From: Wolfenbarger, Jeanne
Sent: Tuesday, March 31, 2015 7:52 AM
To: 'David Soule'
Subject: RE: G11D014D32 - 5001 Grey Hawk Court NW

From: Wolfenbarger, Jeanne
Sent: Monday, March 30, 2015 5:11 PM
To: David Soule
Subject: G11D014D32 - 5001 Grey Hawk Court NW

Project Title: SPUHLER-LASASTER Building Permit #: _____ City Drainage #: F11-D014G
DRB#: _____ EPC#: _____ Work Order#: _____
Legal Description: LOT 32P1
City Address: 5001 GREY HAWK COURT

ENGINEER'S SEAL  1/14/15 DAVID SOULE P.E. #14522	LOT 32-P1 OXBOW BLUFF SUBDIVISION	DRAWN BY JDG
	GRADING AND DRAINAGE PLAN	DATE 01-13-2015
 Rio Grande Engineering 1606 CENTRAL AVENUE SE SUITE 201 ALBUQUERQUE, NM 87106 (505) 872-0999	SHEET # 1 OF 1	JOB #

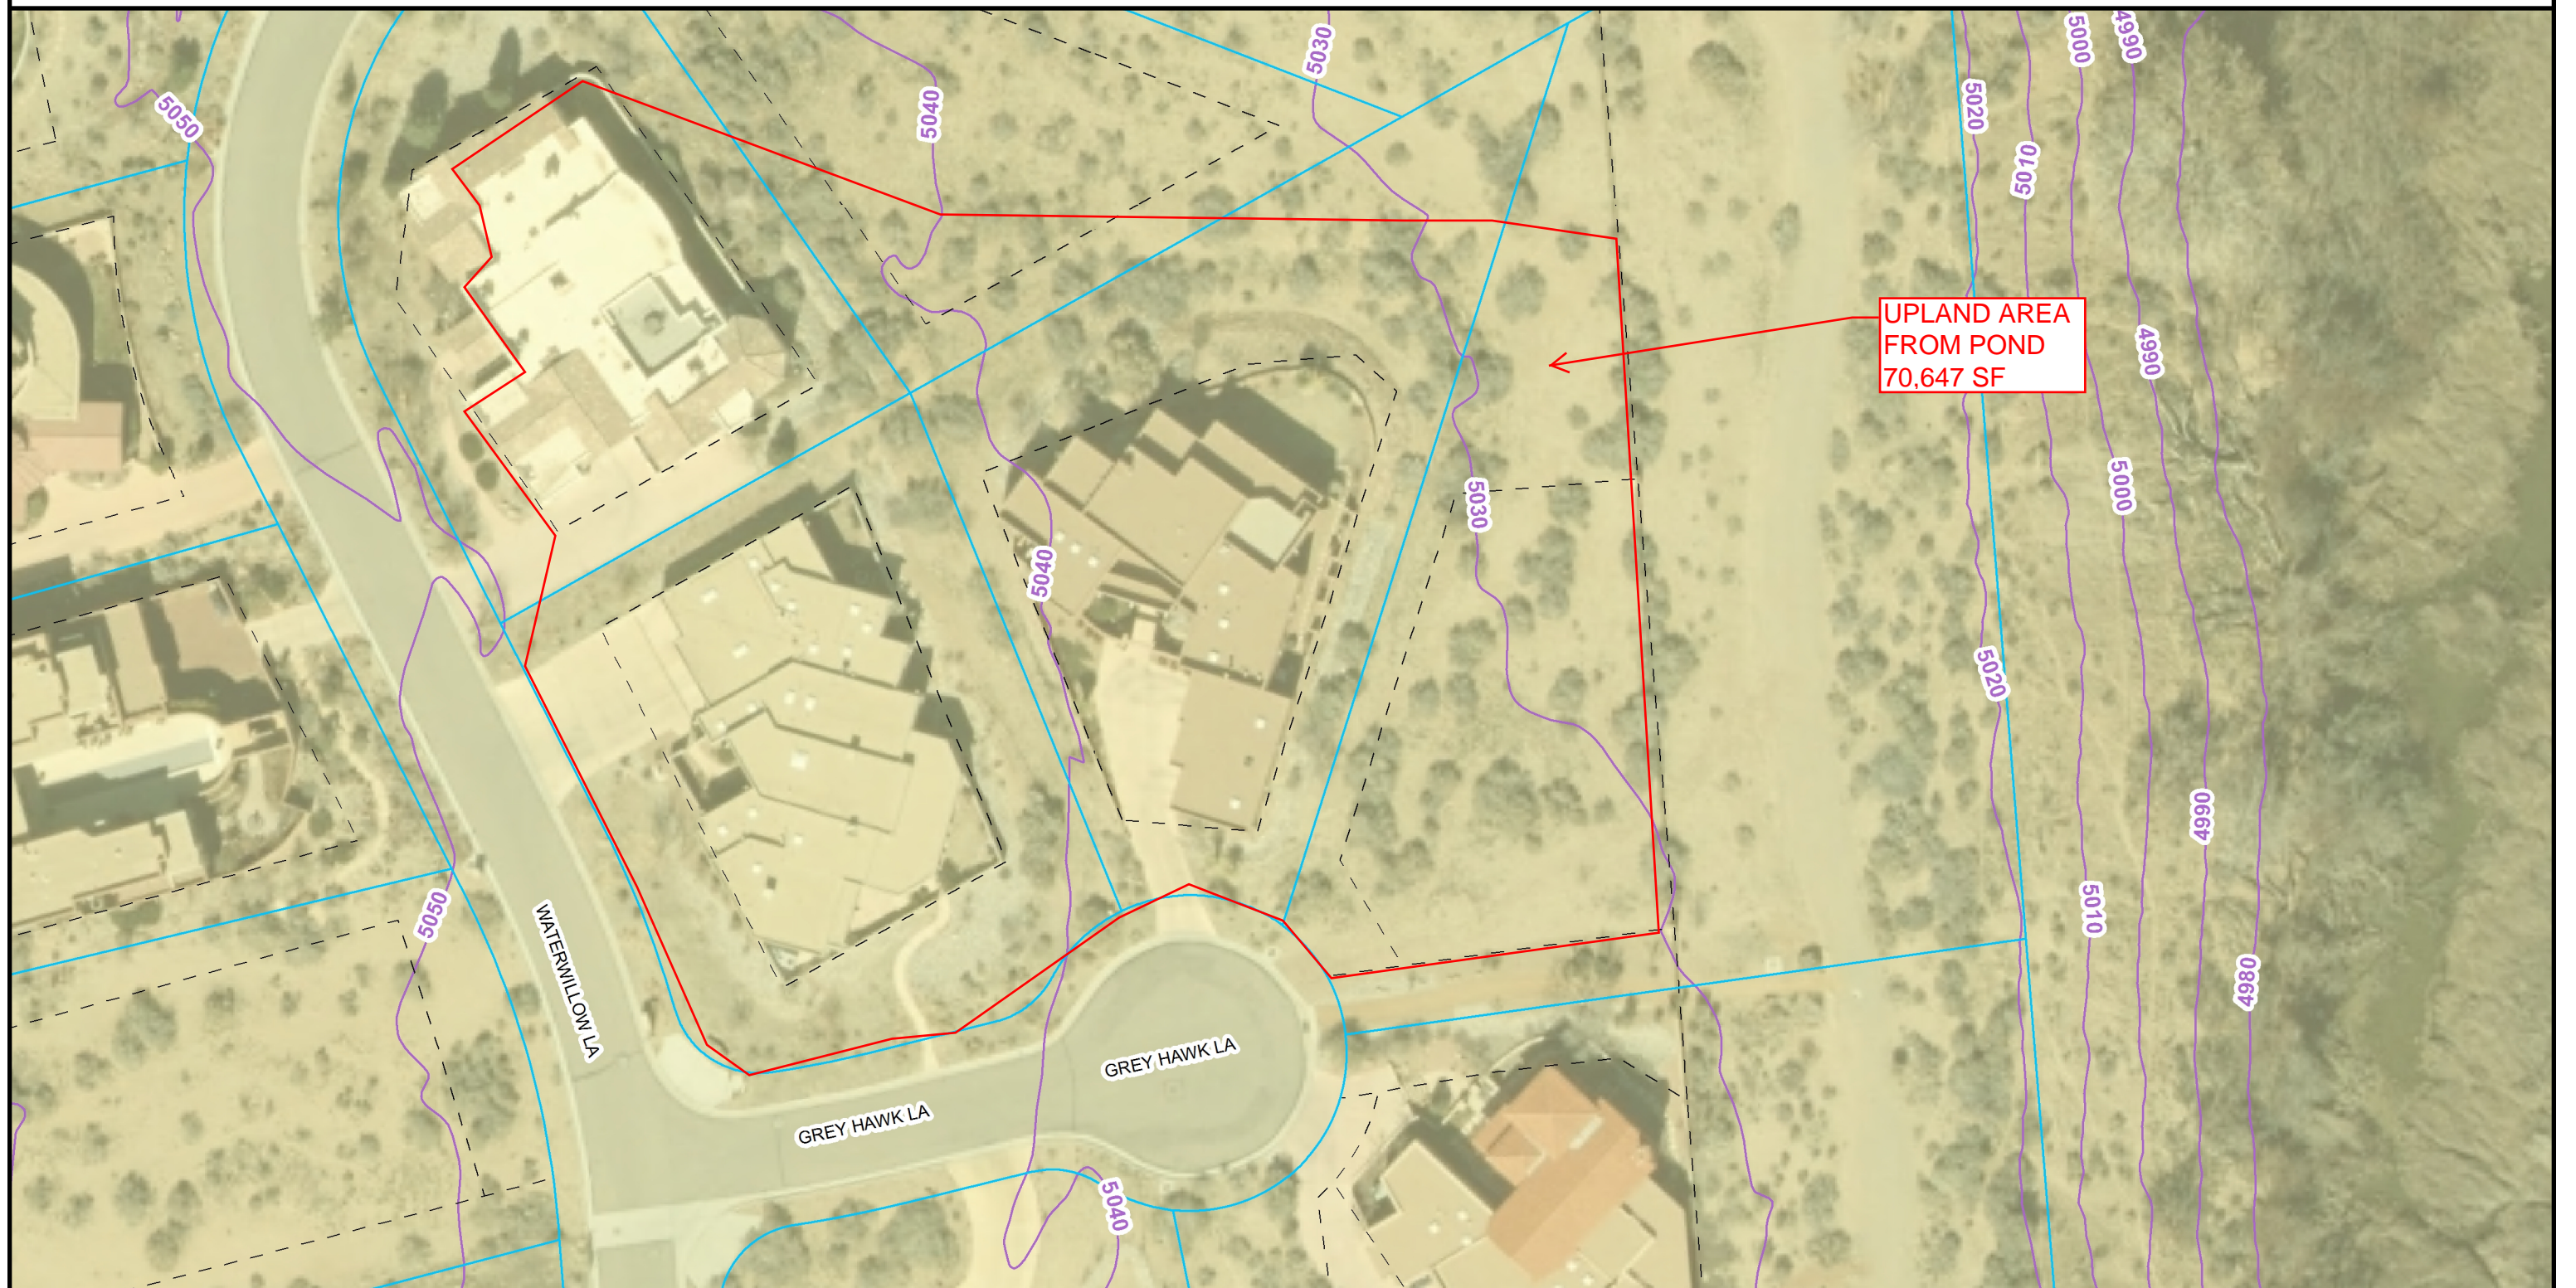
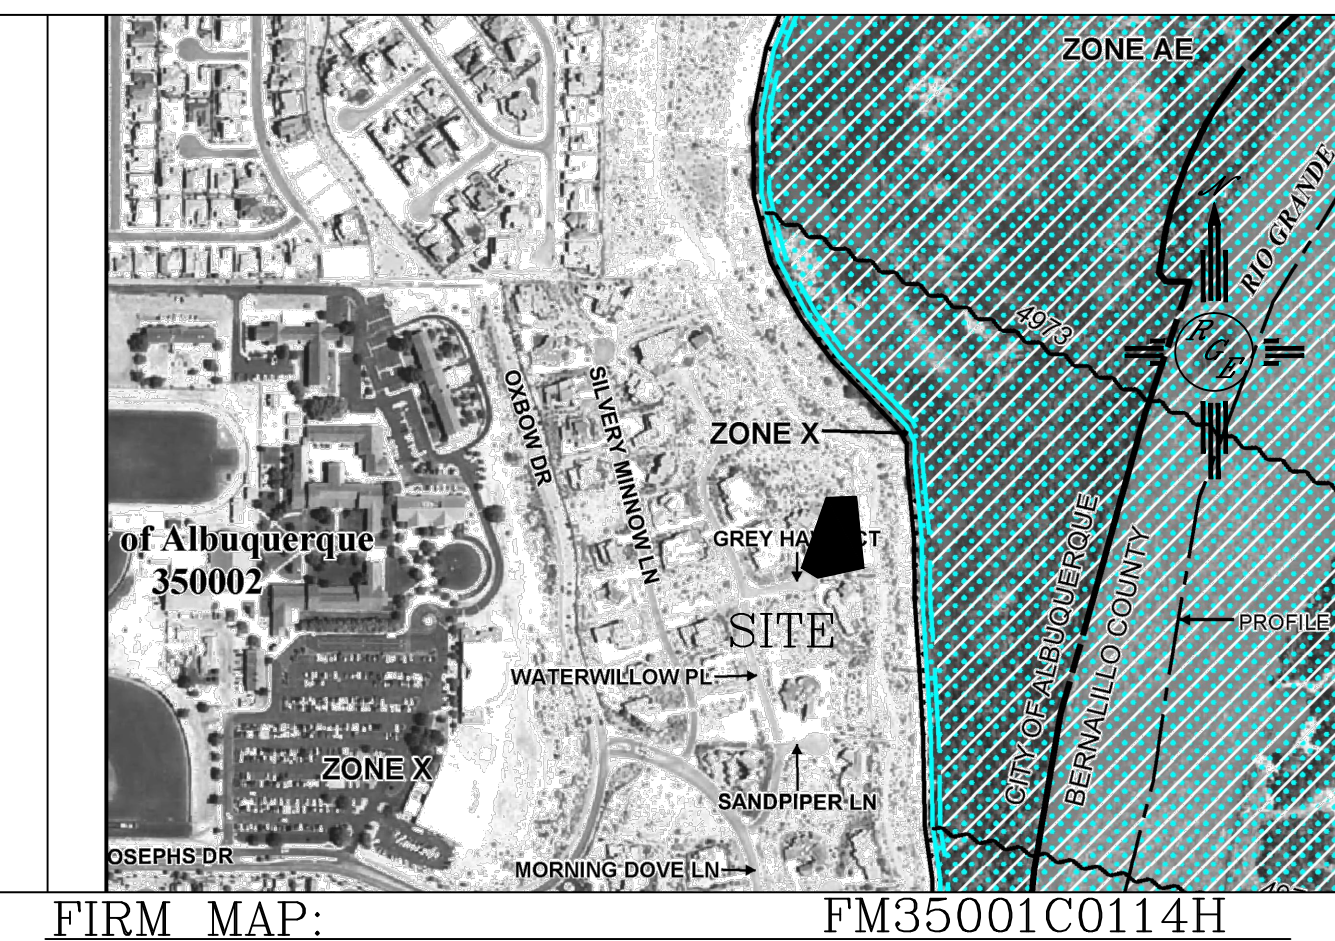
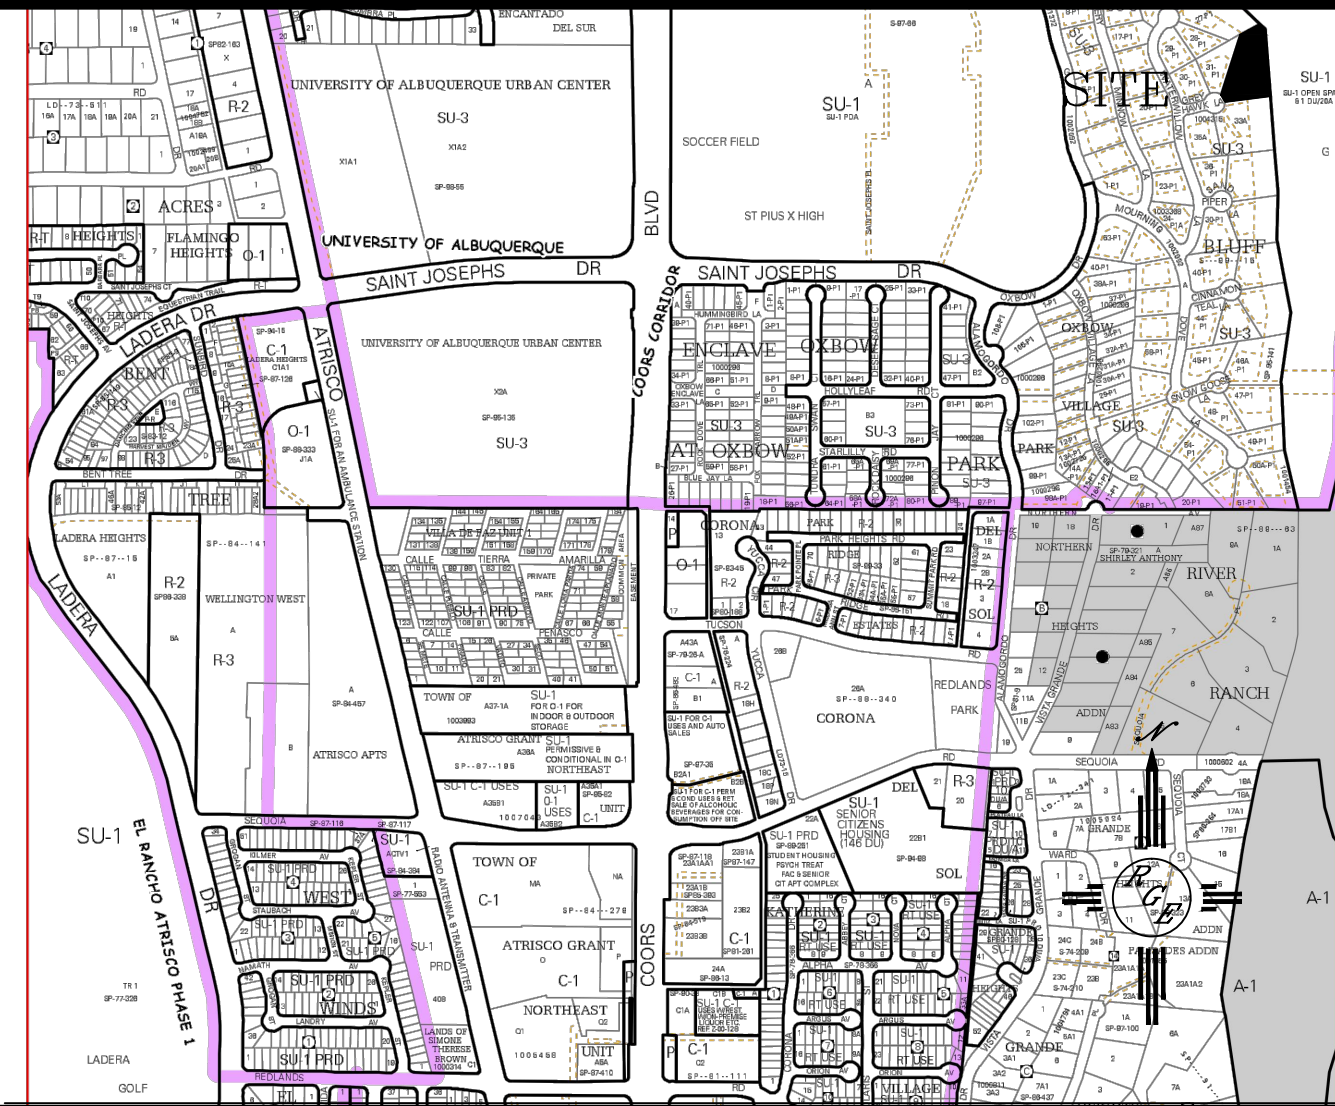
- 1) Show the extent of limits of the off-site basin area that is contributing to the on-site pond area, and include contours.
- 2) For each of the proposed on-site pipe runs, show capacity calculations. Label the flow that each pipe run is conveying.

- 3) Because this site is part of Basin L in the Oxbow Bluff Subdivision, indicate this in the “Drainage Narrative” on the plan. If the site is draining to the beehive inlet, call out the beehive grate and the grate elevation of the beehive grate. Show how the site is draining to this beehive inlet. (You mentioned you would be moving the overflow area to direct the flow to the beehive inlet better, but you mentioned that you could **not** provide a channel on the opposite side of the wall. If there is a wall east of the overflow area, show how drainage gets to this beehive inlet. Will there be an opening in the wall, and how wide/high will it be?) Also, call out cobble size for the overflow and height of overflow area. Judging from the contours, it looks like not all of the flow from the overflow area will be directed to the beehive inlet without creating a channel. Could you explain this? Also, include capacity calculations for the beehive grate, and show existing downstream pipe from beehive grate.

- 4) In the “Drainage Narrative”, also talk about the number of lots that contribute to the off-site flow that is entering the site and contributing to the 4.09 cfs. With the amount of flow entering the pond, shouldn’t the “required flow” be larger than 4.09 cfs? Shouldn’t it include both the on-site and off-site flows? Discuss whether this off-site flow area is contained within “Basin L” from the Oxbow Bluff Subdivision. Discuss that the flow is being conveyed from the storm drain to the river.

- 5) When providing the necessary acceptance letter from Bohannon-Huston, Inc., please include the flow that is being accepted into the beehive inlet from the on-site pond. (If there is updated information from B-H that supports your report from the 1997 report, provide excerpts. From what you are saying, there was a lot of information that Bohannon-Huston had updated from the 1997 report.)
